From: planning
Subject: Consultation on planning application 3/2014/0438 land east of Chipping Lane, Longridge

From: Fiona Pudge [<mailto:Fiona.Pudge@sportengland.org>]
Sent: 24 June 2014 14:36
To: Daniela Ripa
Subject: RE: Consultation on planning application 3/2014/0438 land east of Chipping Lane, Longridge

Drawing:
Proposed Boundary Details

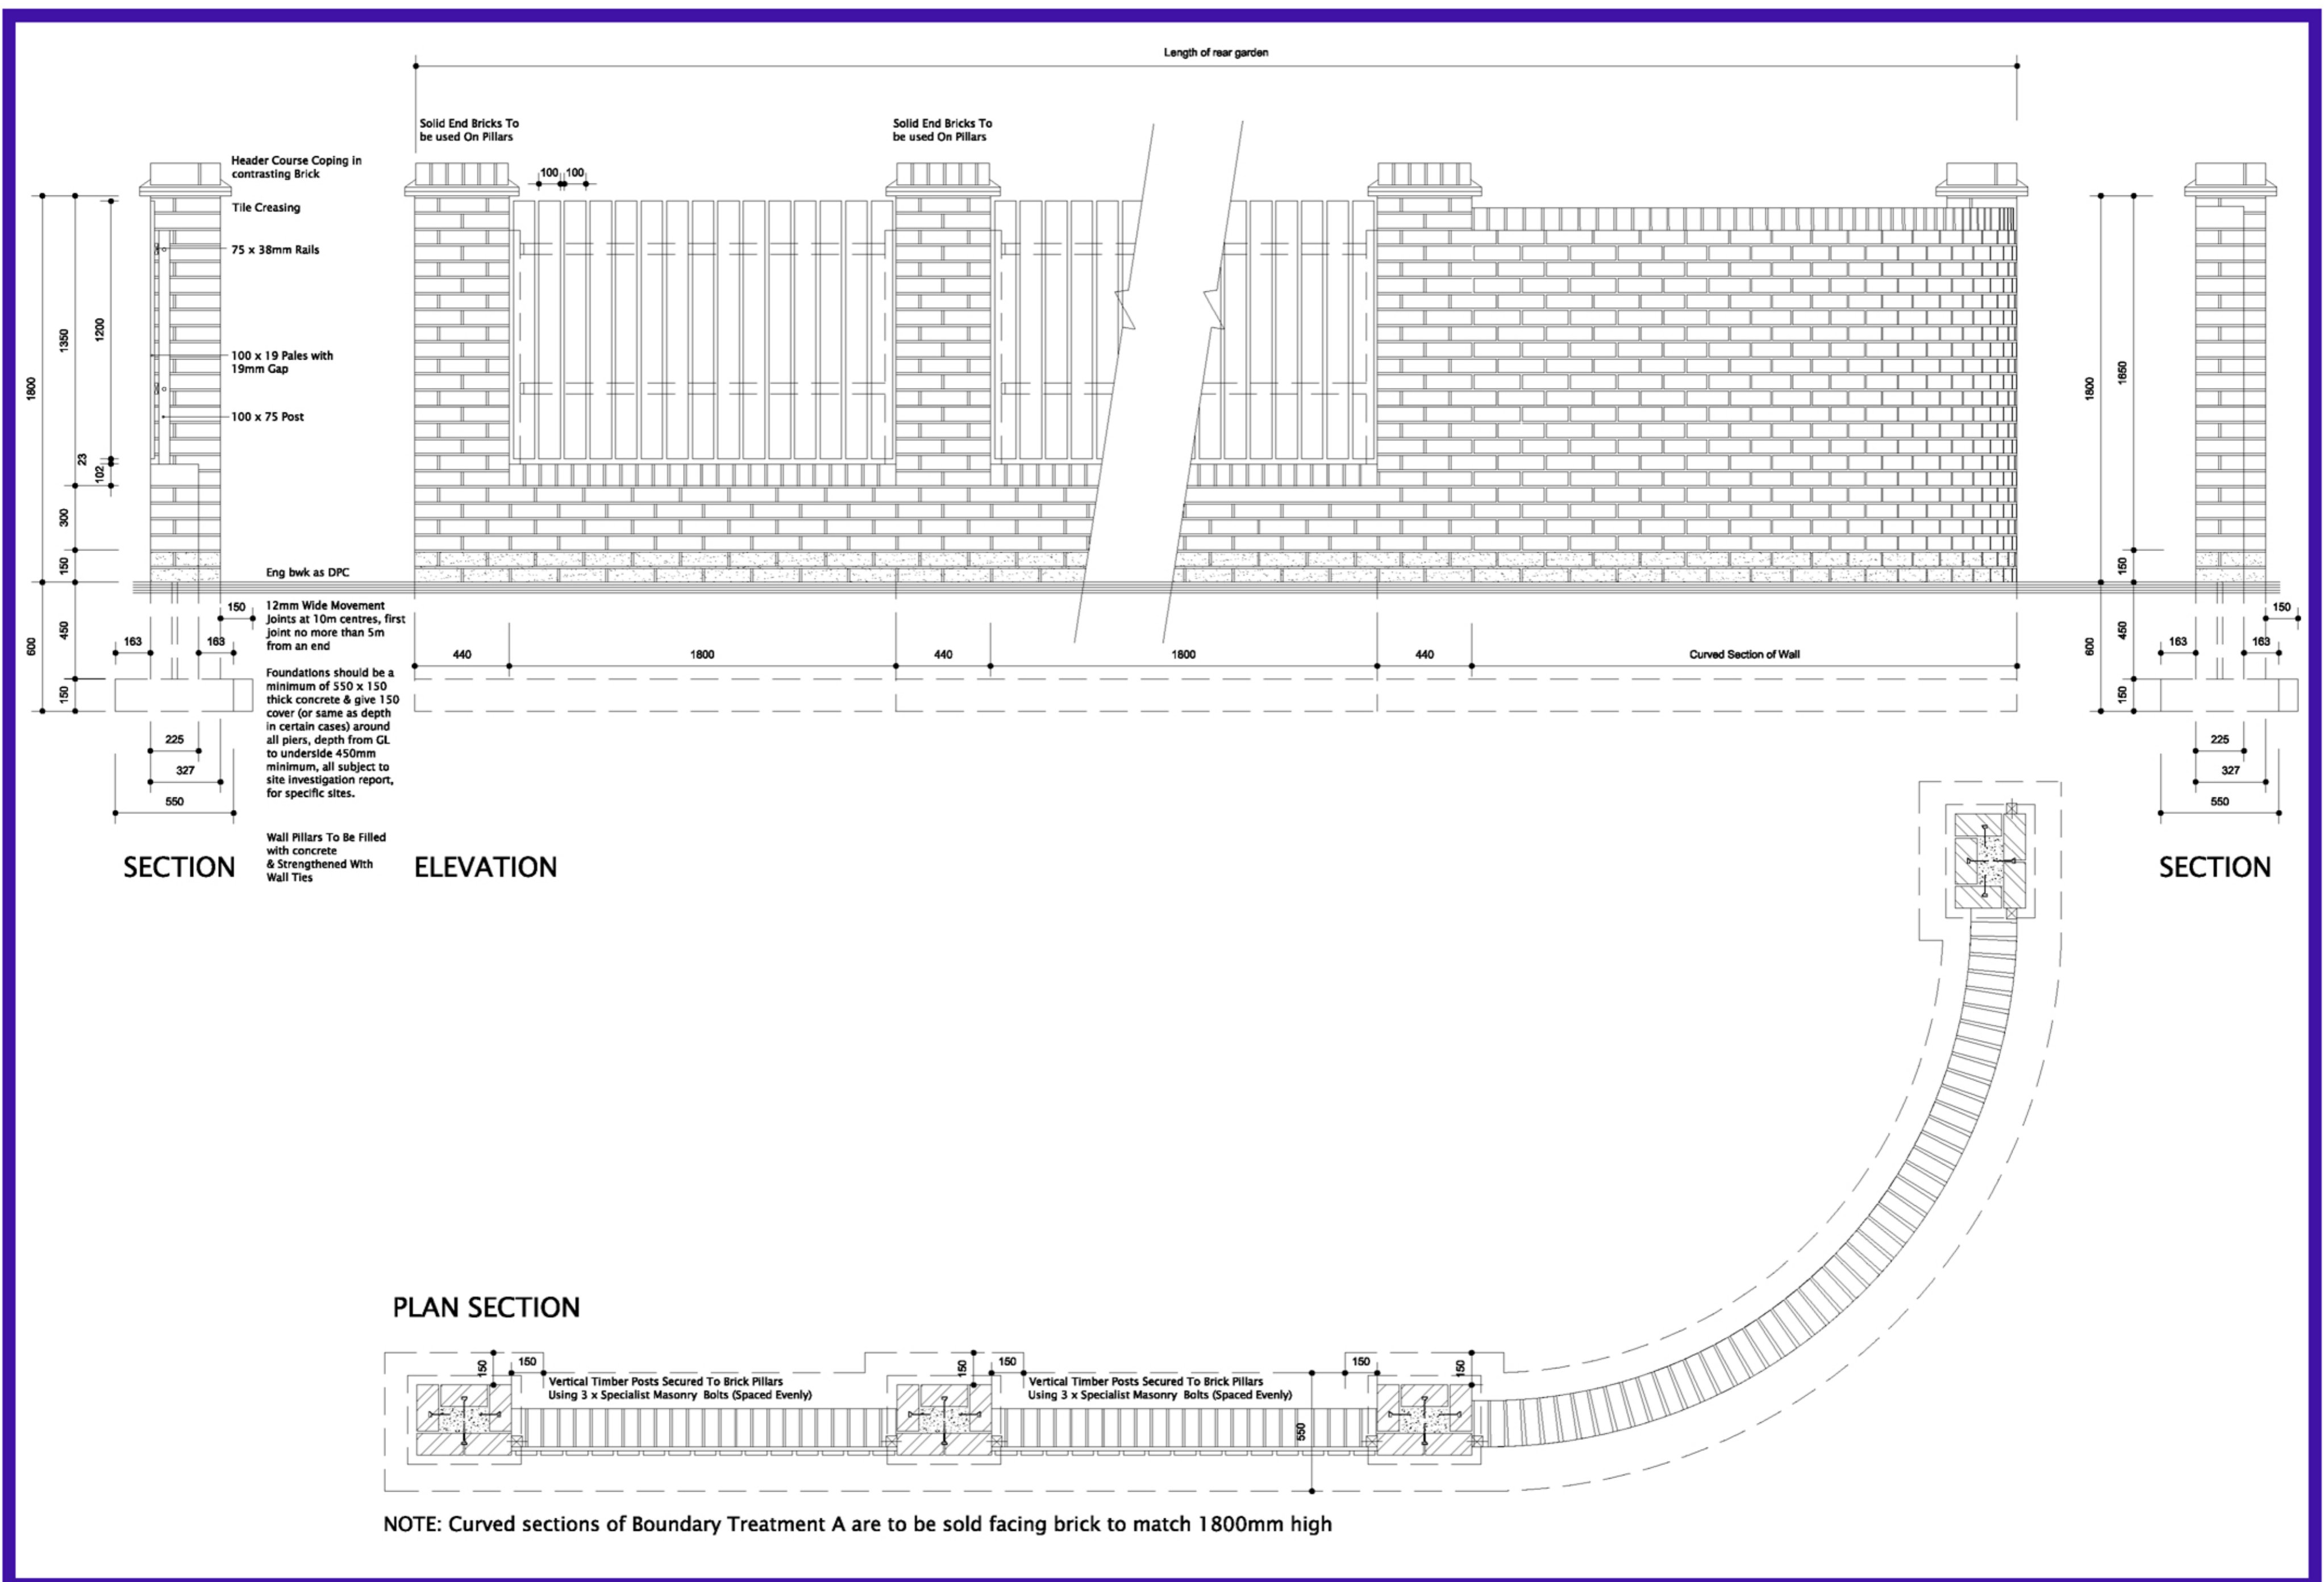
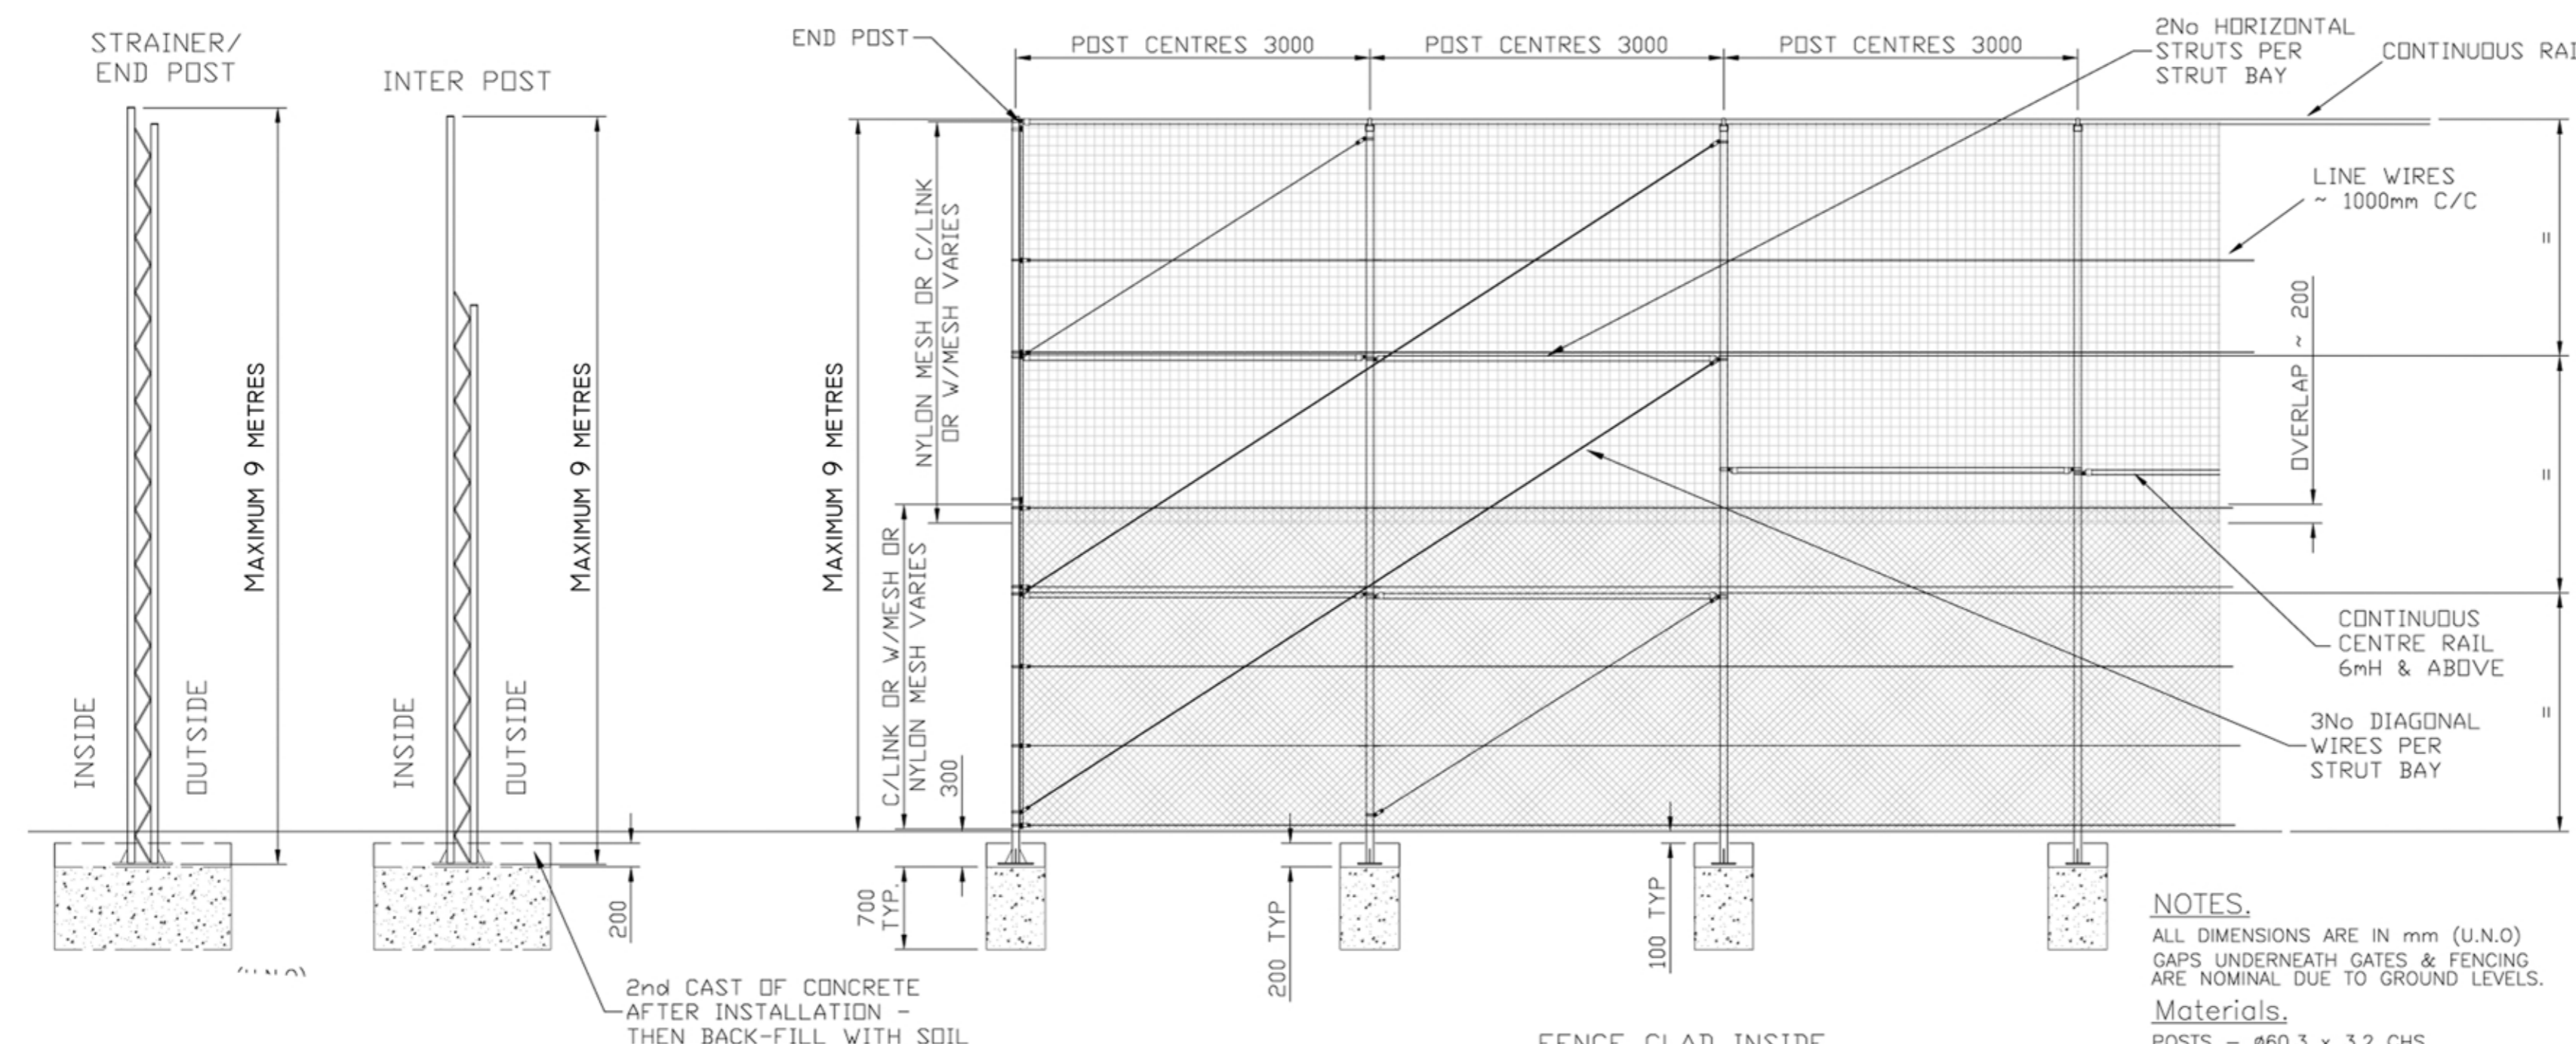
1. *Yes, building housing adjacent to the ground without creating protection from ball strikes would potentially jeopardise the use of the ground. Once the property is constructed the club would be liable for damage to persons or property under civil law (Miller vs Jackson 1977 is the precedent case law) and therefore the cost of using the ground could be uneconomic if a number of civil suits were pursued. In recent times a number of legal challenges have been made against grounds with close proximity to housing including injunctions being sought to prevent play. Without adequate protection we would request you seek a statutory objection. Furthermore it should be noted that 9m on the East edge of the ground is likely to be inadequate due to the length of the boundary. Typically at this distance (circa 40m from the square) a fence of 12m in height would be expected but this should be subject to a detailed risk assessment and design.*

2. *Whilst telescopic netting is technically possible it is not practicable over such a large area without very high cost for both construction and maintenance. The imposition of the maintenance costs of this on the cricket club would be unreasonable.*

My conclusion is that a risk assessment to determine the level of ballstop fencing is required. This could be included as a condition if you are minded to approve the application. If the requirement ballstop fencing is removed then Sport England would have no choice but to lodge a statutory objection because of the prejudicial nature of the development.
